# Table of Amendments to the draft Development Consent Order

## Deadlines 1, 4, 6 and 8

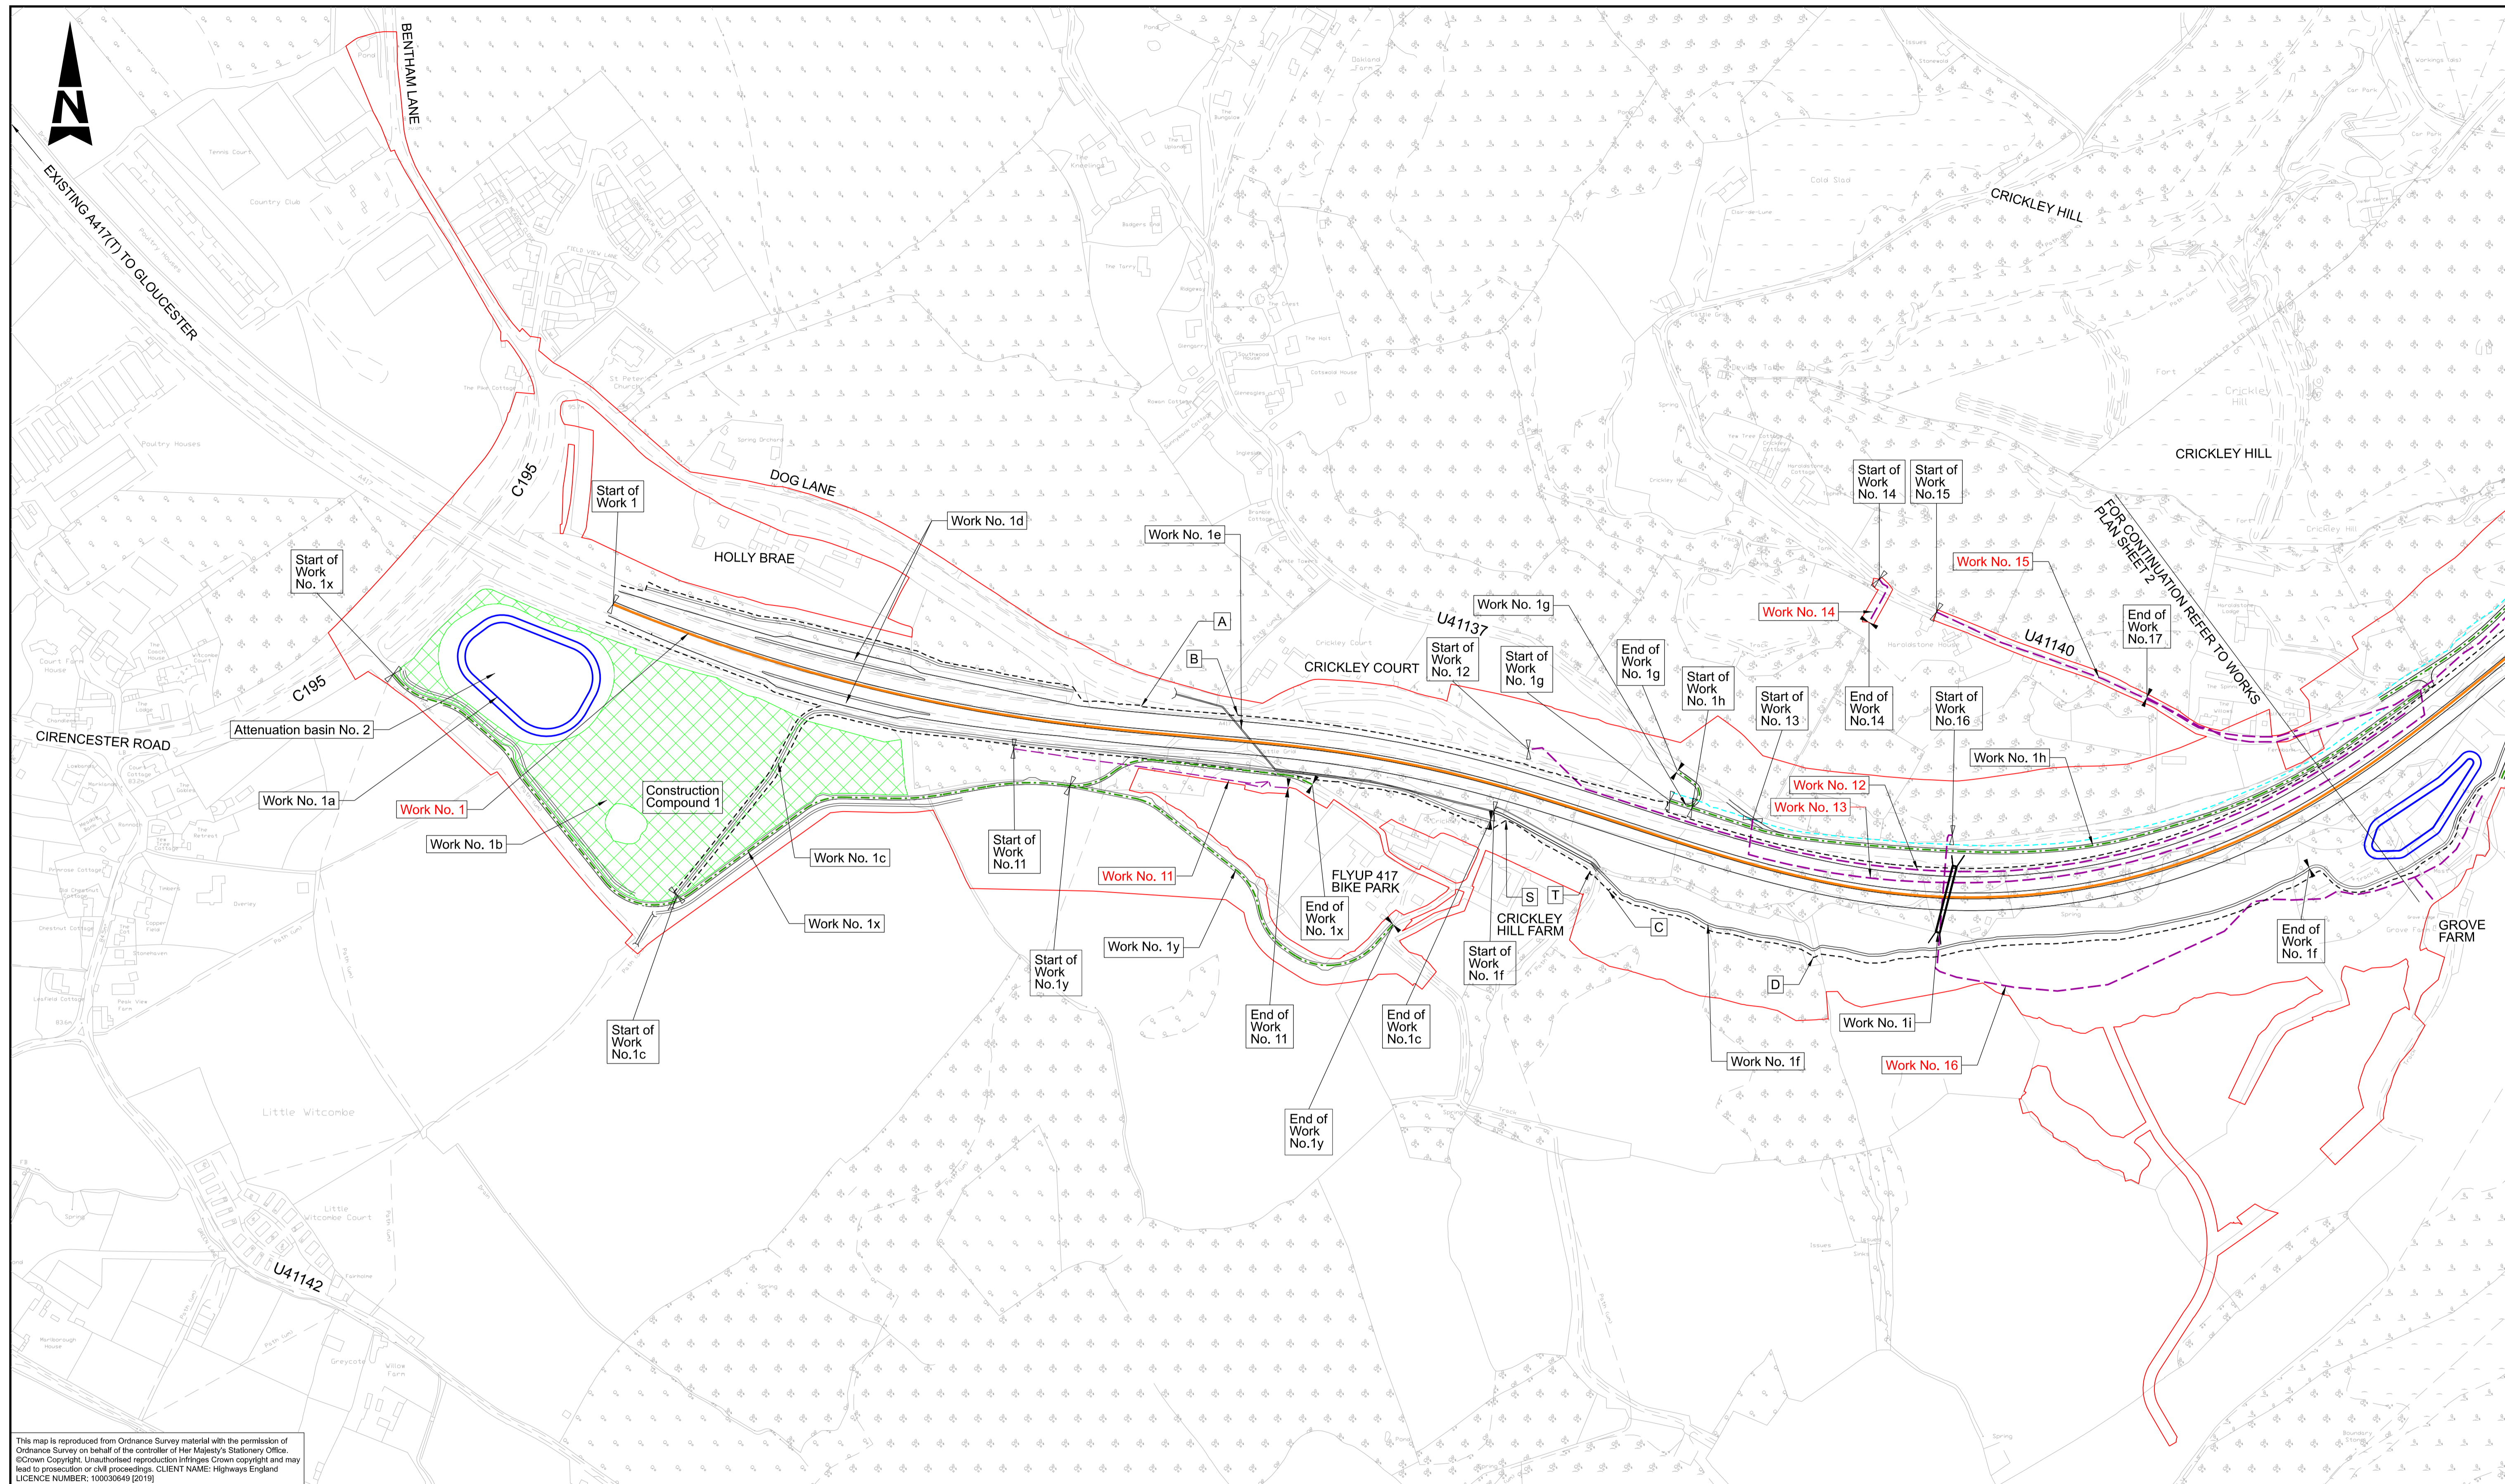
<b>Article 40(2)</b>	A reference to paragraph “(1)” has been added within paragraph (2).	To correct a formatting error.
<b>Schedule 1</b>	Under Work No. 1(x), the reference to “sheet 1” of the works plans has been updated to “sheet 2”.	To correct a typographical error.

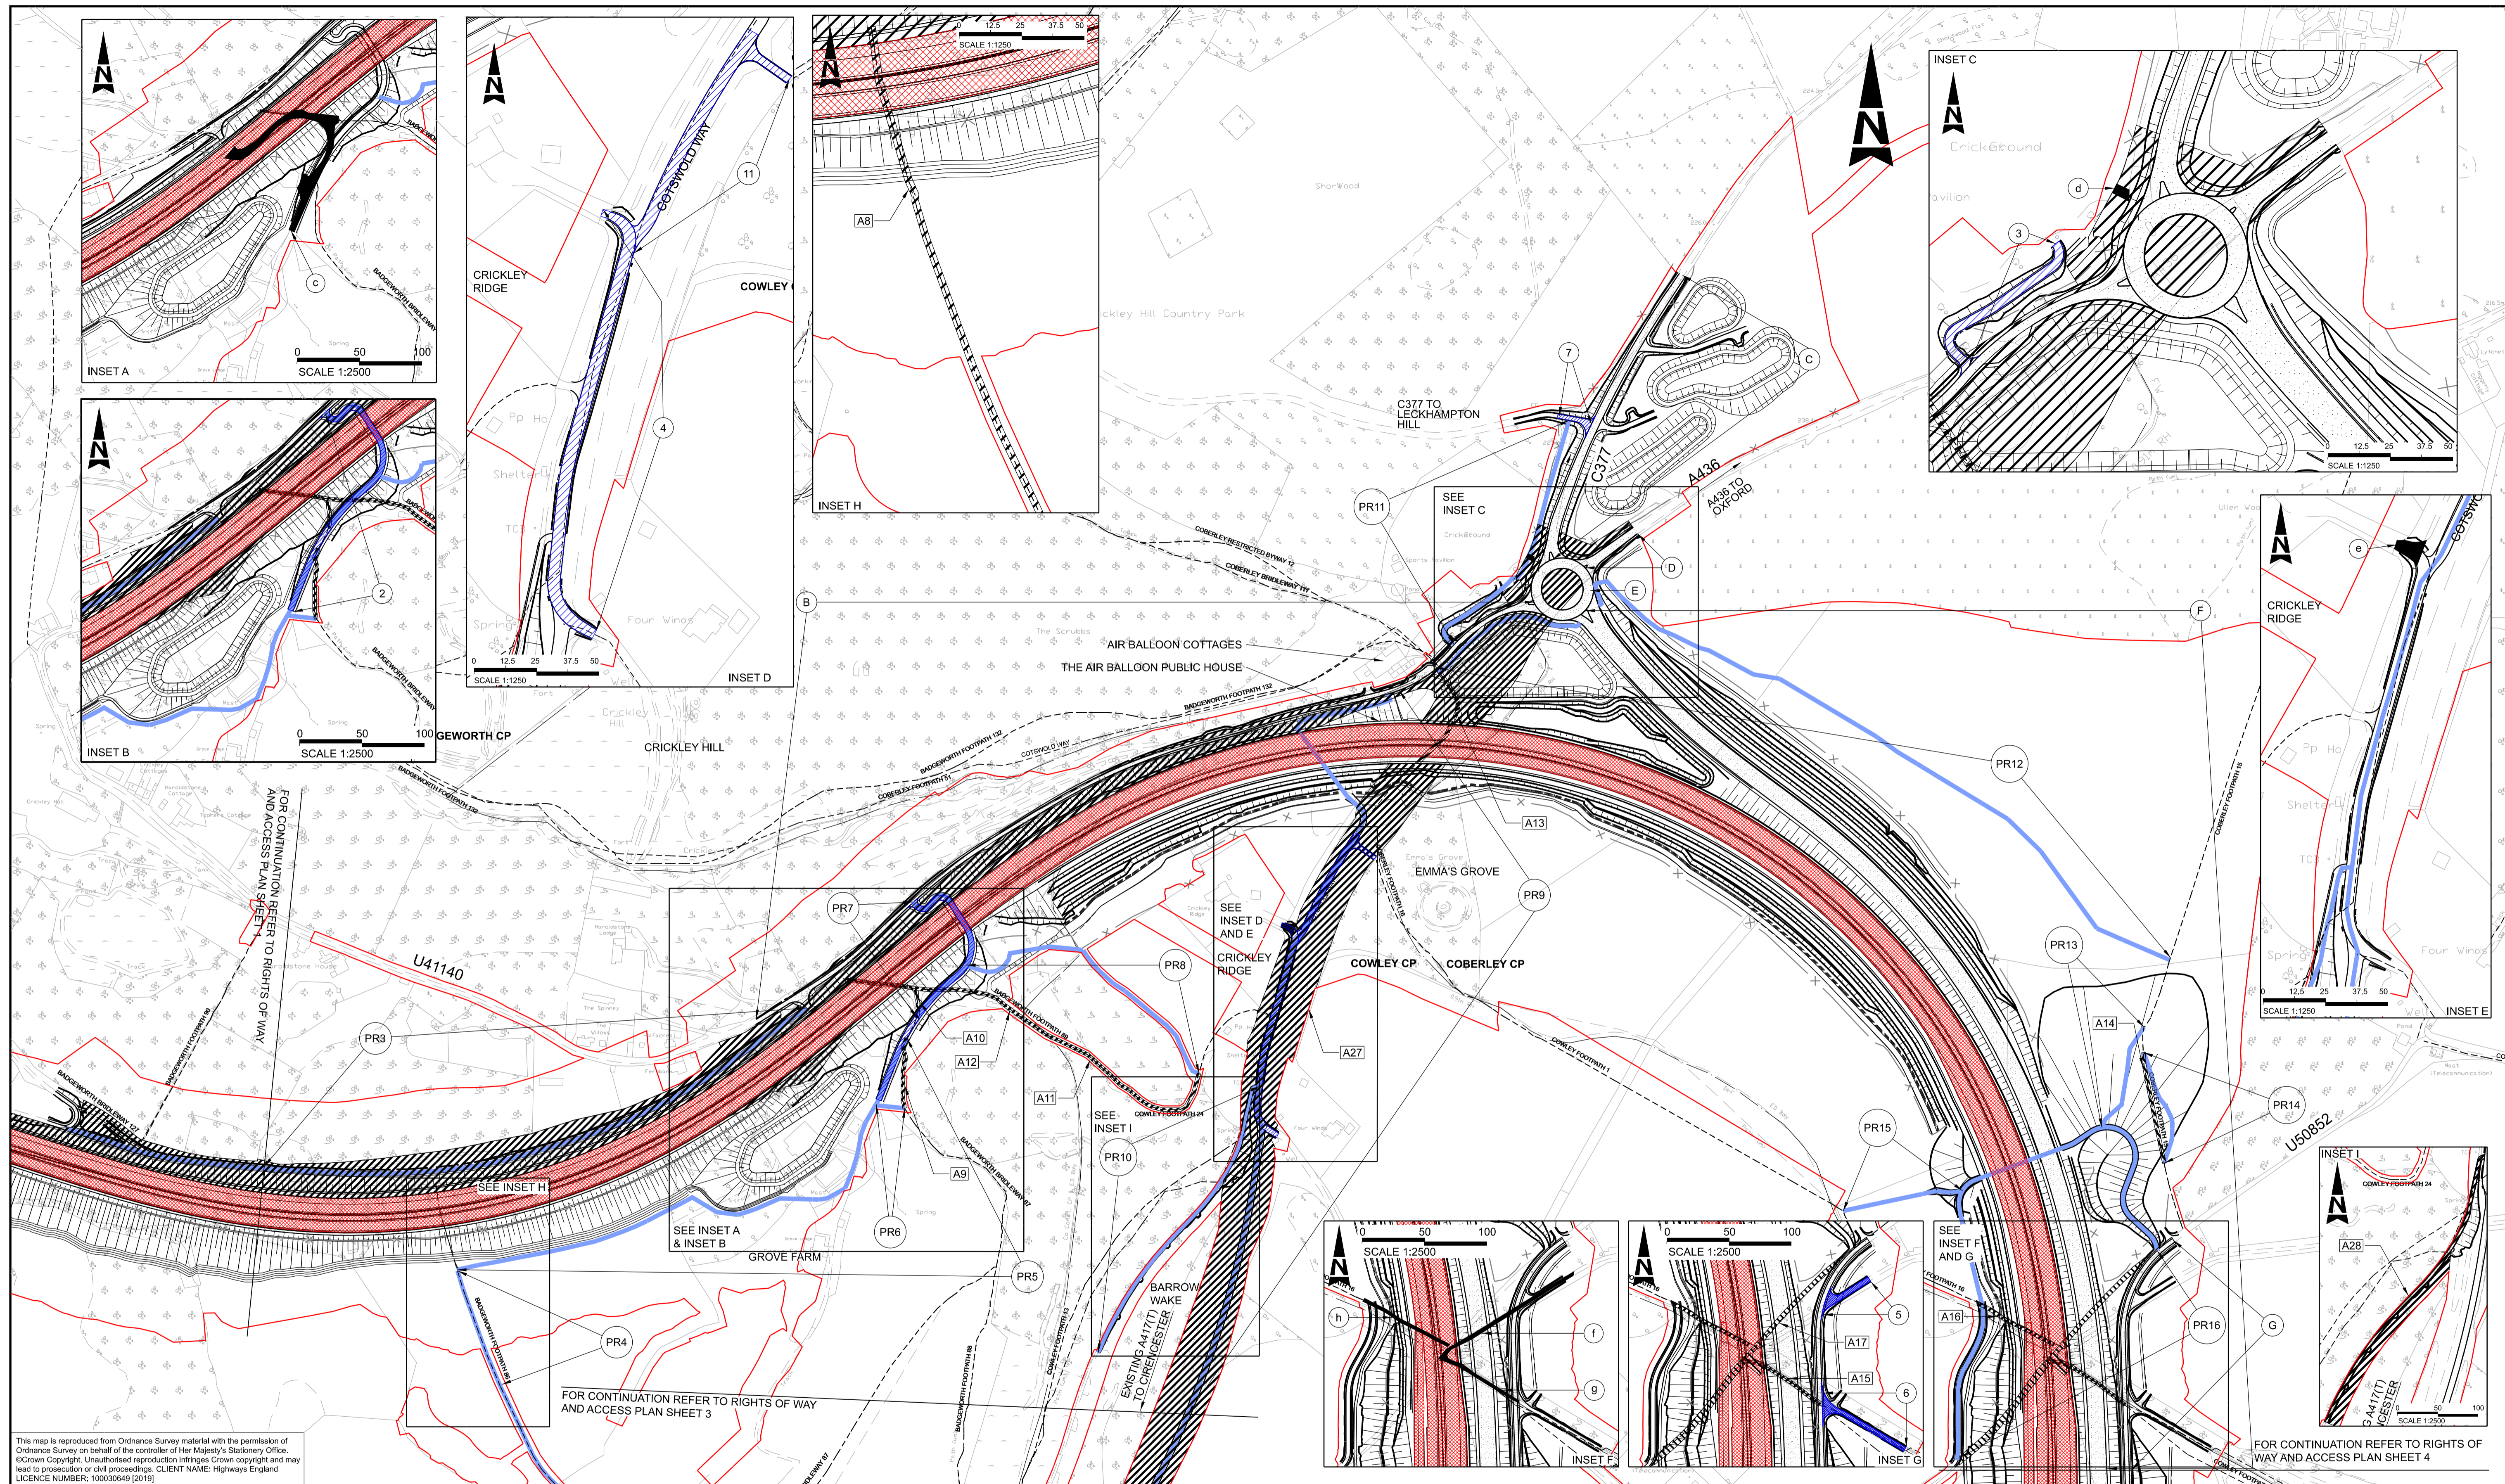
Article/Requirement/Schedule Number	Amendment	Reason
<b>Schedule 4, Part 4</b>	The description of the new private means of access to Crickley Hill Farm with Reference 1 has been updated to refer to “for a length of 846 metres, south of its existing access”.	For clarification purposes.
<b>Schedule 4, Part 4</b>	<p>A new private means of access with Reference 12 has been inserted as a substitute for the access to Crickley Hill Farm east of C195 Bentham Lane follows:</p> <p>A new private access to Crickley Hill Farm to the east of C195 Bentham Lane for a length of 320 metres south of its existing access</p>	To reflect the design change request at FlyUp Bike Park.
<b>Schedule 4, Part 4</b>	New entry with Reference 11 inserted.	To introduce a new private access to Emma’s Grove south west of the existing A436 roundabout, as shown on sheet 2 of the updated rights of way and access plans submitted at Deadline 4.
